Application No: AW/353/20/OUT
Site Address: Land adjacent to 1 Cambridge Walk Aldwick PO21 5RL
Description of works: Outline application with some matters reserved for 1 No. new dwelling.

Thank you for your internet representation made on 14th March 2021 which has been recorded as an objection with the comments as follows:

Site Plan shows area bounded by: 491668.61, 99621.47 491810.03, 99762.89 (at a scale of 1:1250), OSGridRef: SZ91739969. The representation of a road, track or path is no evidence of a right of way. The representation of features as lines is no evidence of a property boundary.

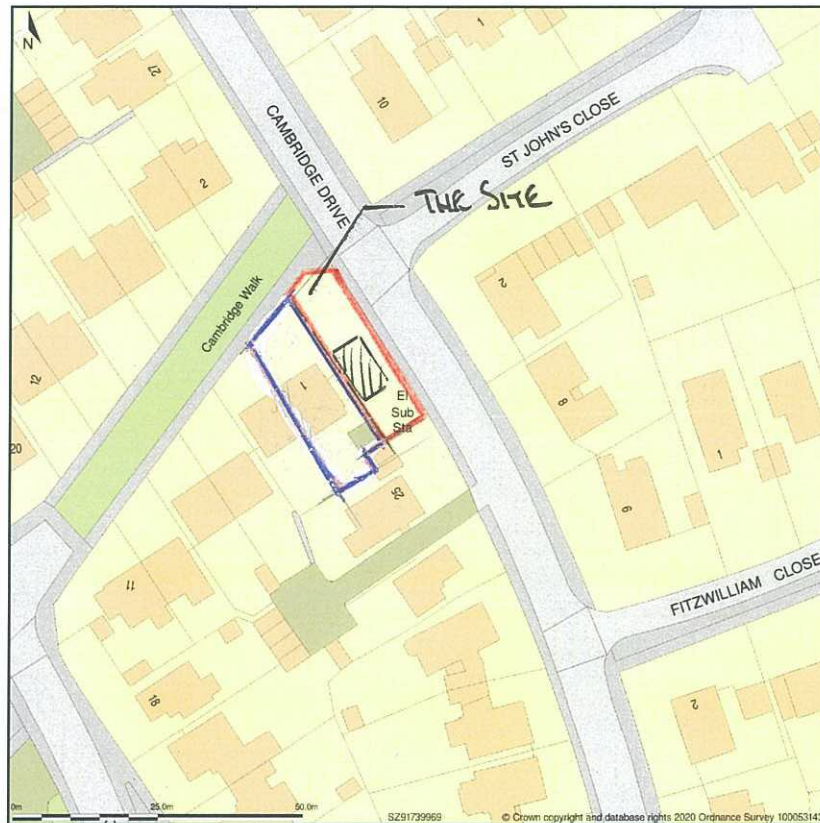
The proposed dwelling, along with a 6ft fence, would protrude beyond the current building line and therefore be intrusive to the open plan street scene of Cambridge Drive. This would be detrimental to visual amenity and would compromise the overall open plan character of the West Meads estate.
